KITTITAS COUNTY

DEPARTMENT OF PUBLIC WORKS

MEMORANDUM

TO: All Staff
FROM: Public Works Plan Review Team
DATE: August 15, 2023
SUBJECT: BL-23-00009 Rarden

BOUNDARY LINE ADJUSTMENT BL-23-00009

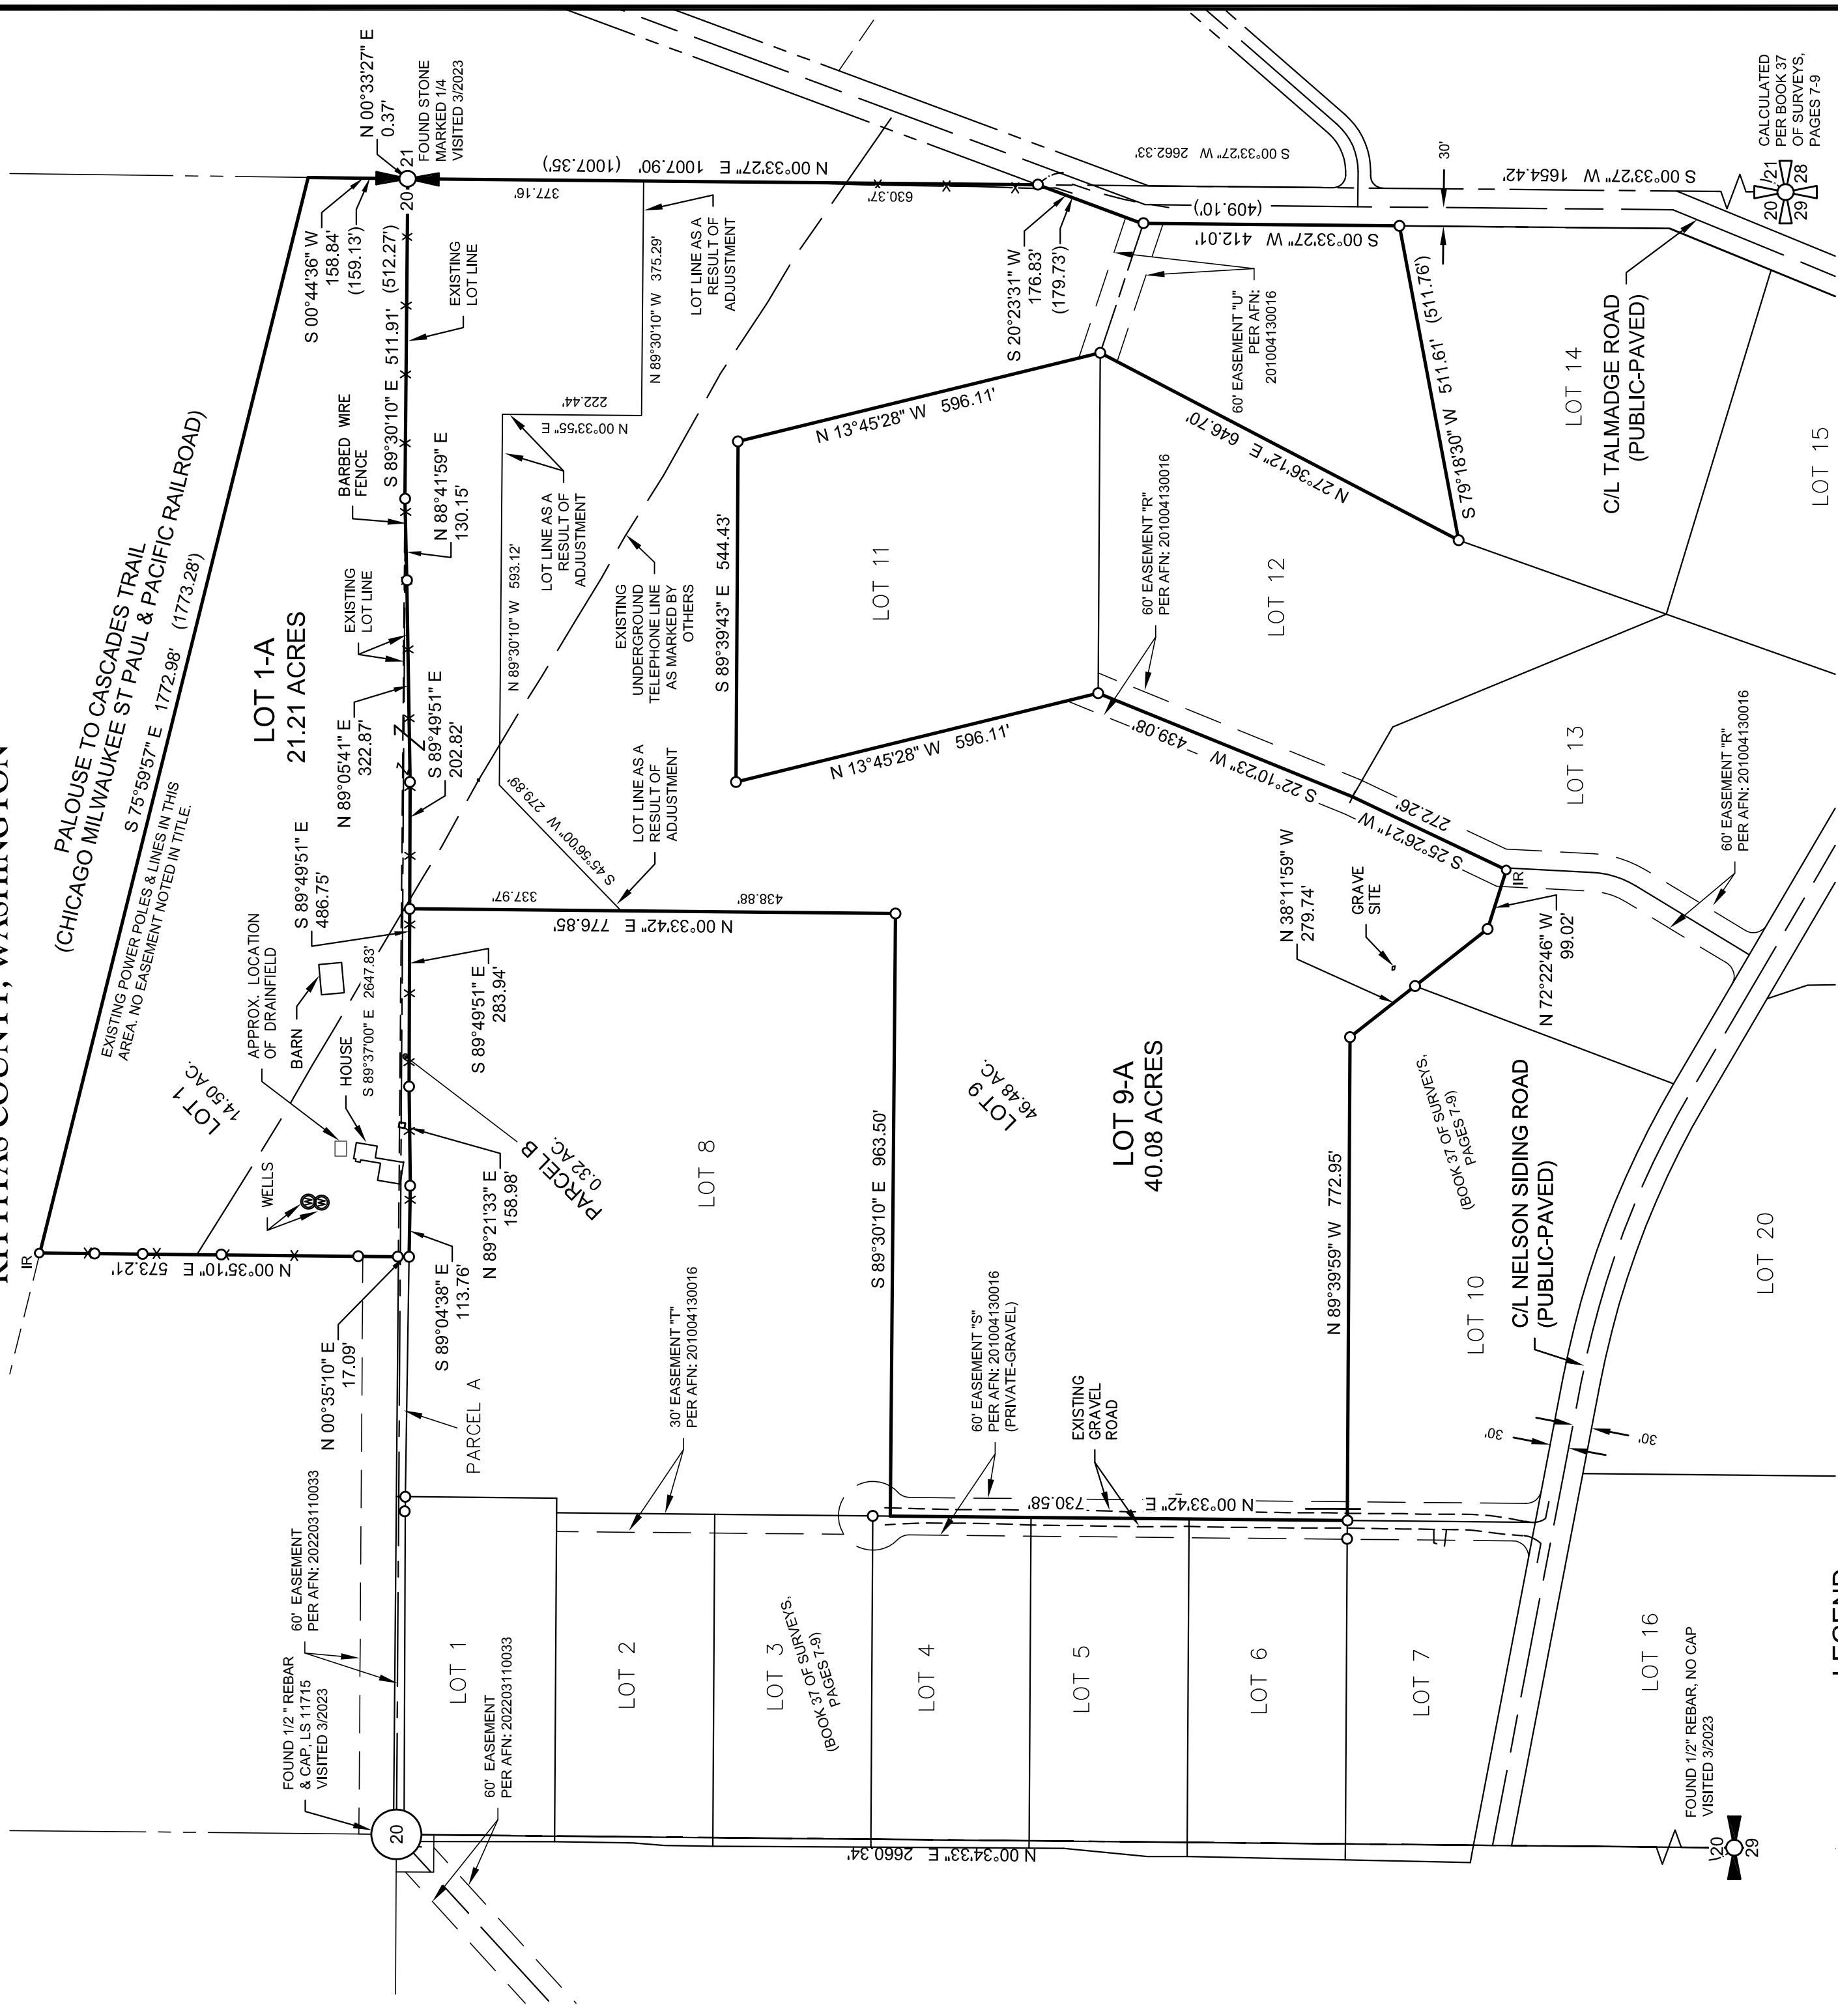
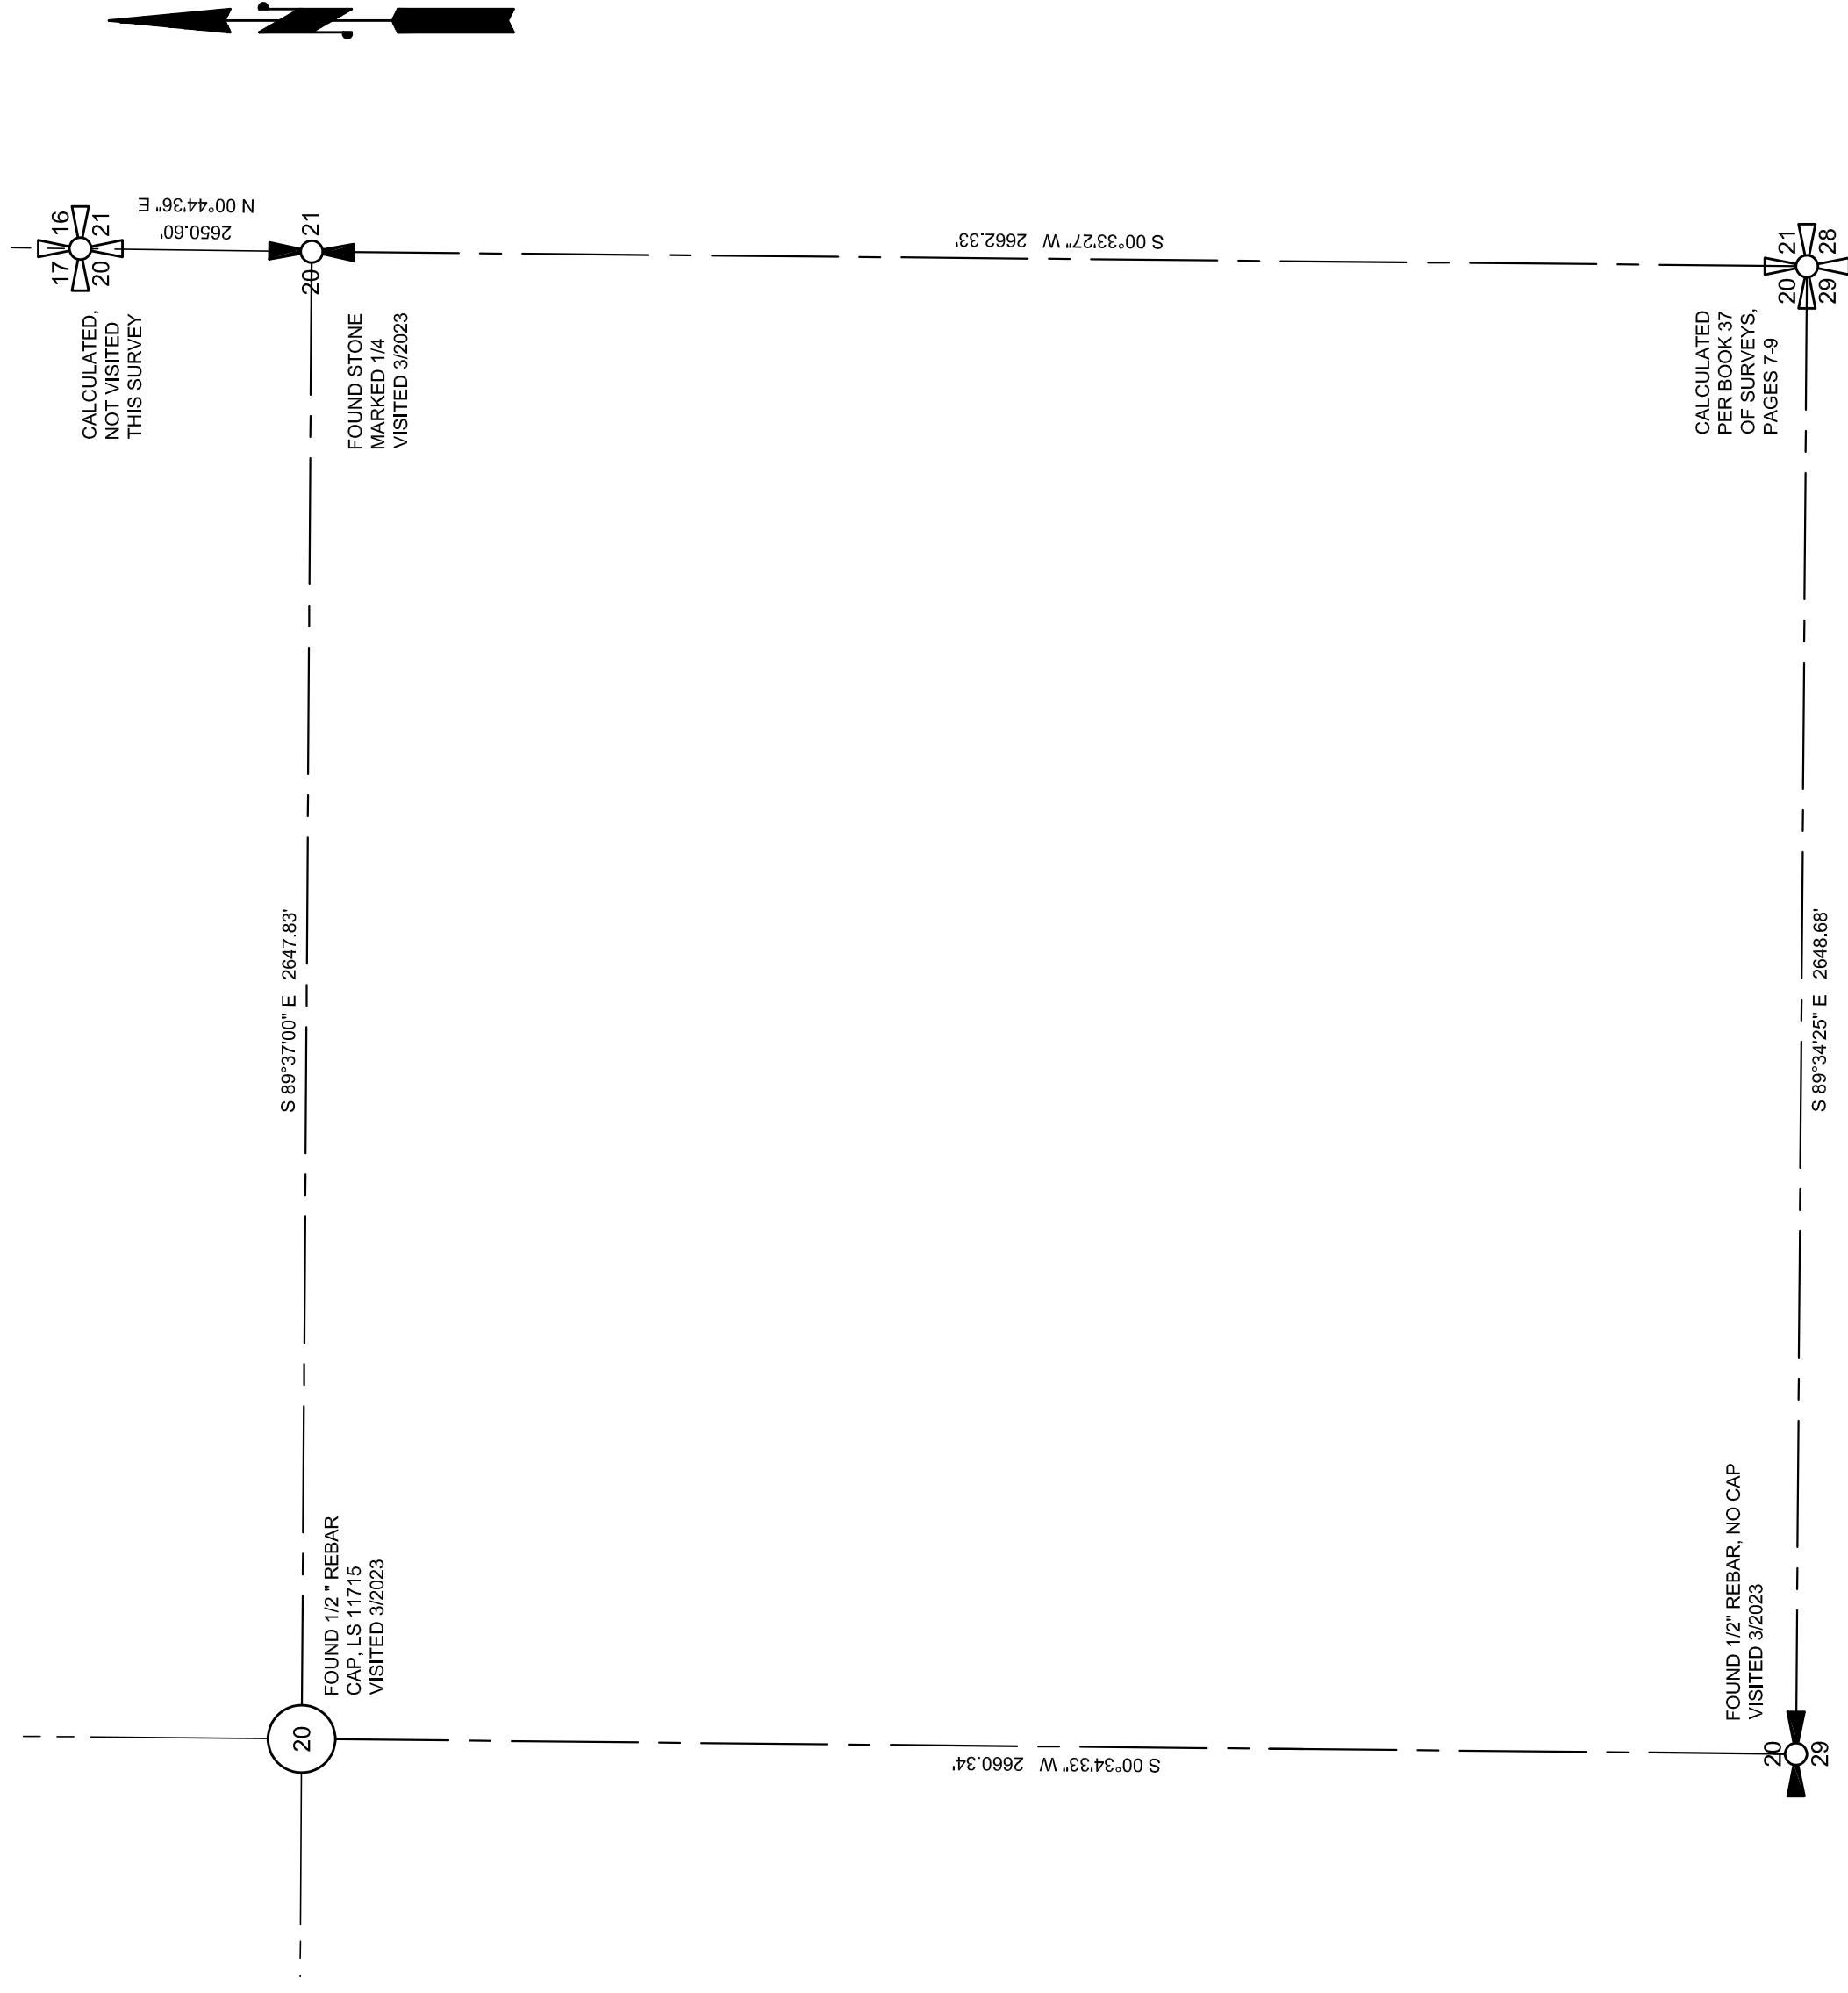
<p>Of note: While a basis of bearing statement that references a single point and State Plane Coordinates is insufficient to serve as a true basis of bearing, it does meet the requirements of state law.</p> <p>UPDATE 8/15/2023</p> <ol style="list-style-type: none"> 1. At minimum the corners for the new division line shall be shown on the face of the survey and set in the field. 2. The inclusion of record bearings shall be shown along the East line of Lot 9, where they deviate from record. (3 occurrences) 3. The position of the East Quarter corner remains ambiguous. As a suggestion, sheet one should have a note to “see detail on sheet 3”, and sheet 3 should have a detail window that clearly shows the relationship of the found stone and the historic position. Exaggerated linework may be required to clearly show this. 4. Sheet 2, Note 9 should note whether the found east quarter, or historic east quarter is being used for the basis of bearing.... Based on the map, I believe that the historic position is being used. 5. The Northeast Section Corner is shown as calculated. Please include how this was calculated by referring to a record document, of calculation methods. 6. The section breakdown on sheet 3 should make note of the 5’ discrepancy on the West line, (showing record distance would be suitable, but if additional knowledge about this can be shared, it would be a benefit). 7. The Southeast Section corner is shown as calculated, from SUR:37-7, but there is a slight difference in the South line distance, and the internal angle does not match. Please provide a little more information on how this calculated position was determined. 8. Sheet 3, Section Corner Notes, East Quarter Corner, is missing the page reference. (Book, 37, Pages 7-9) 9. The detail window on this page should clearly show the North section lines, east section lines, found stone position and historic/calculated/record section corner position, at a suitable scale to clearly determine the difference. (JT)
